From: Martyn White
Sent: 05 March 2019 10:40
To: Planning.Responses
Cc: Zac Denton
Subject: R/304/18/HH & R/305/18/L

R/304/18/HH & R/305/18/L

Elm Cottage is a detached, flint building which fronts on to The Street. It has a small dormer and porch to the front elevation. All of the windows are painted casements. It is listed as grade II, and located within the Rustington Conservation Area.

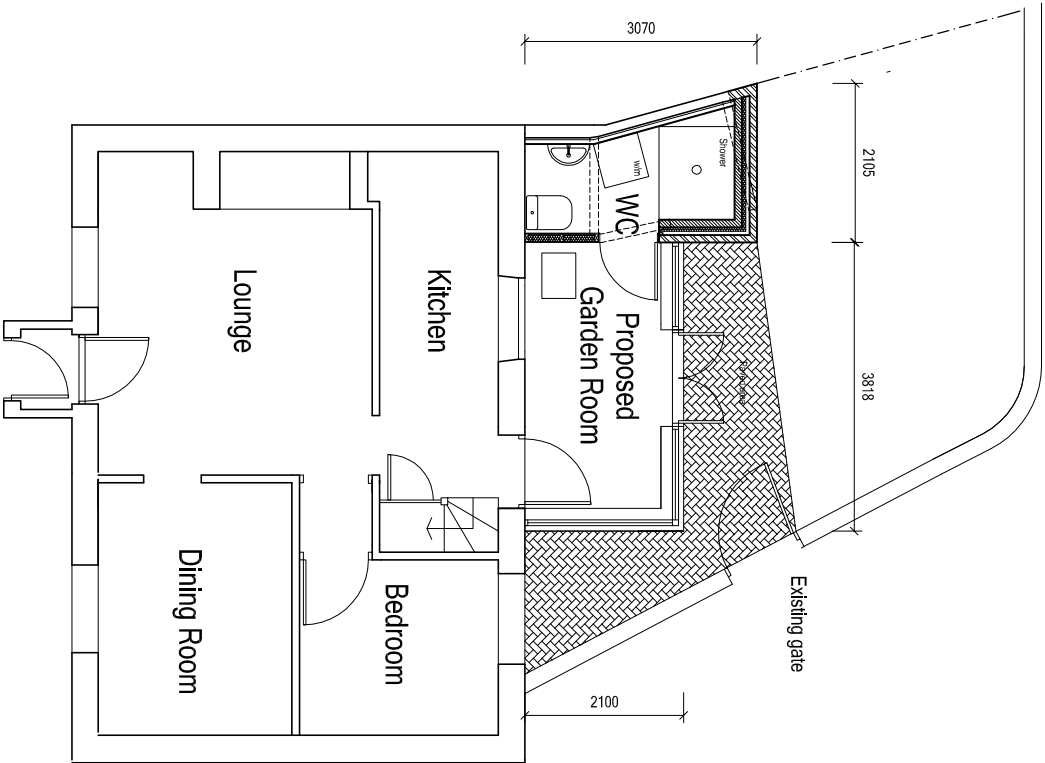
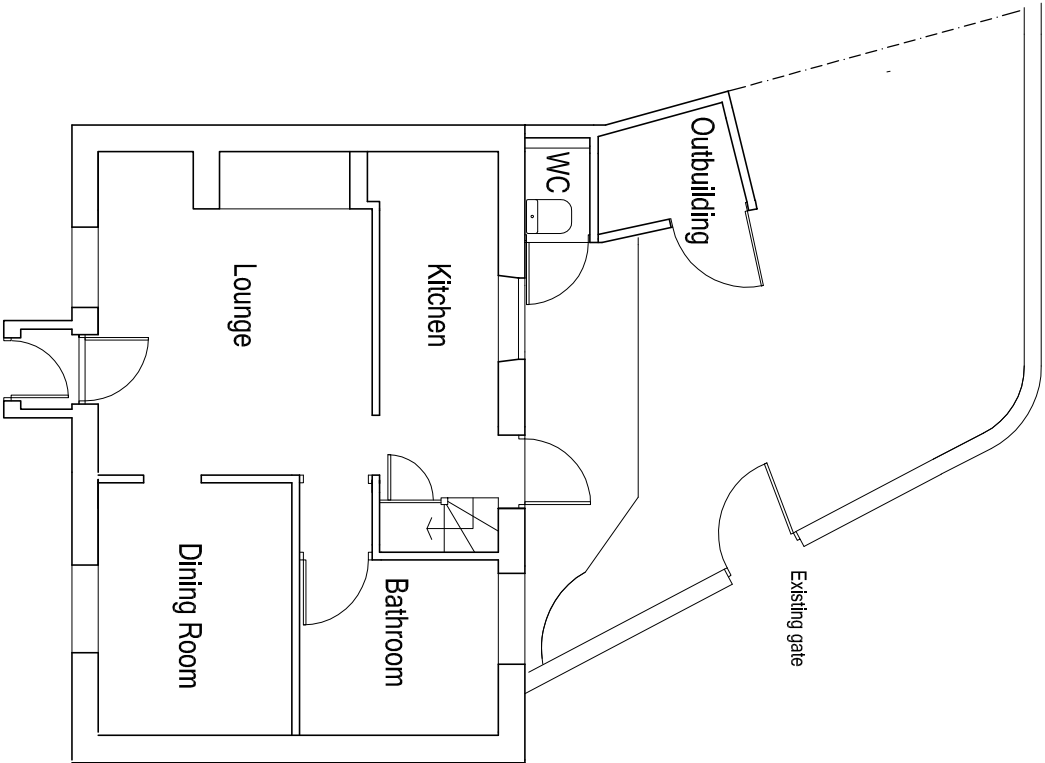
The relocation of the bathroom to the first floor is generally considered to be acceptable. Every attempt must be made to ensure that existing pipe runs are used for the new pipes, and that no historic fabric is affected.

However, there does not appear to be any information which clearly indicates how the services to the relocated bathroom will be treated. Will any external pipework be required? If so, this will be required on the plans.

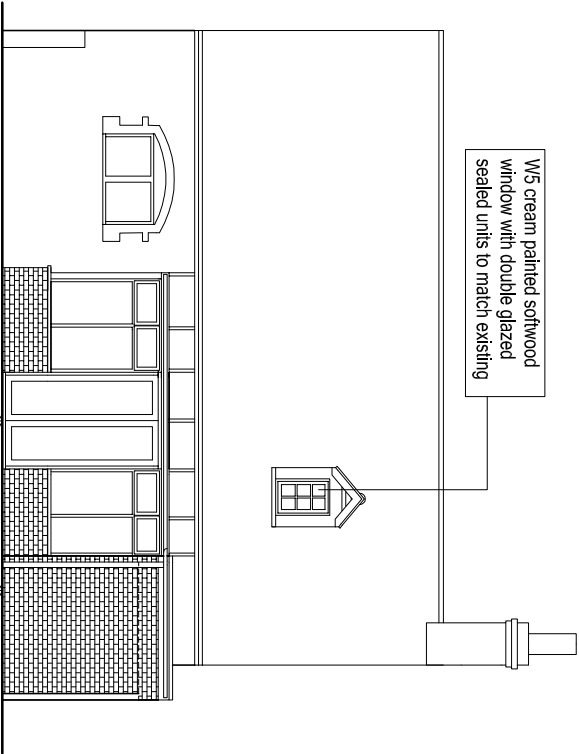
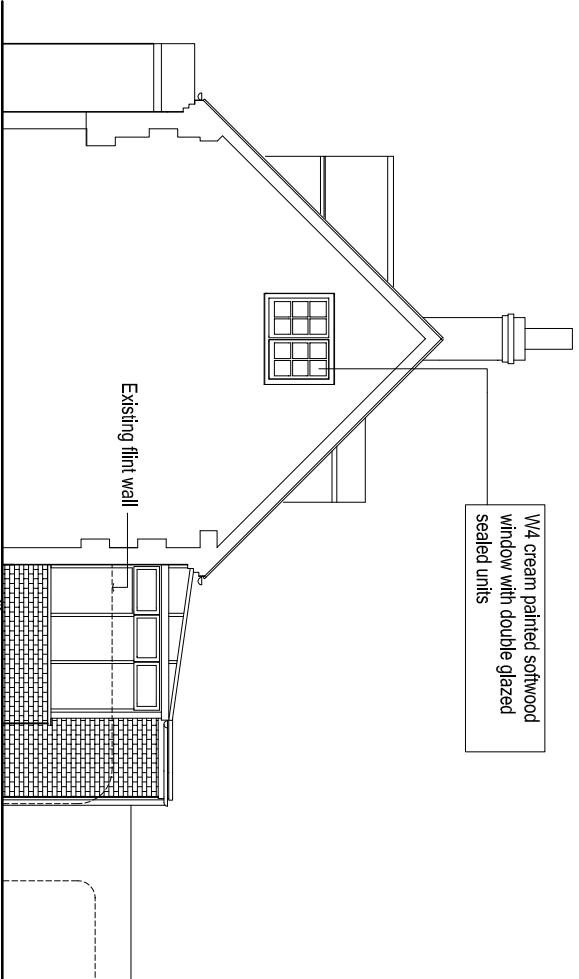
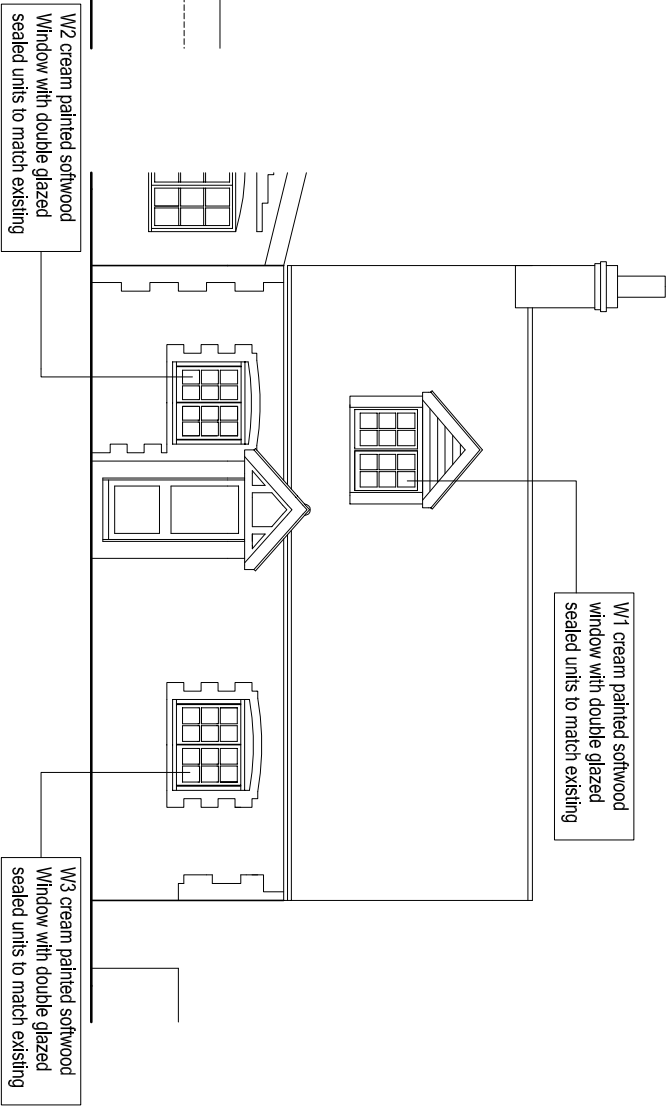
No information is provided with regards to the new joinery/glazing of the garden room, which should be provided for by way of condition. Further, details of the proposed bricks should be approved by the LPA in order to ensure that they reflect the host dwelling.

Reference is made to the deterioration of the existing windows, however, no information is provided to back up that statement. It is common practice to include some pictures with such applications by way of evidence.

The drawings provided indicate that the glazing bars will not differ from the existing, and that there is a limited variation in terms of appearance to accommodate the double glazed units. However, it is not clear if the double glazed units will be of a standard design, or the slimmer design which is sometimes considered acceptable in listed buildings. If the units are of the standard design, and measurements, then their use will not be supported.

Therefore, on balance, subject to the confirmation that the slimmer glazing units will be used, the replacement windows can be supported.
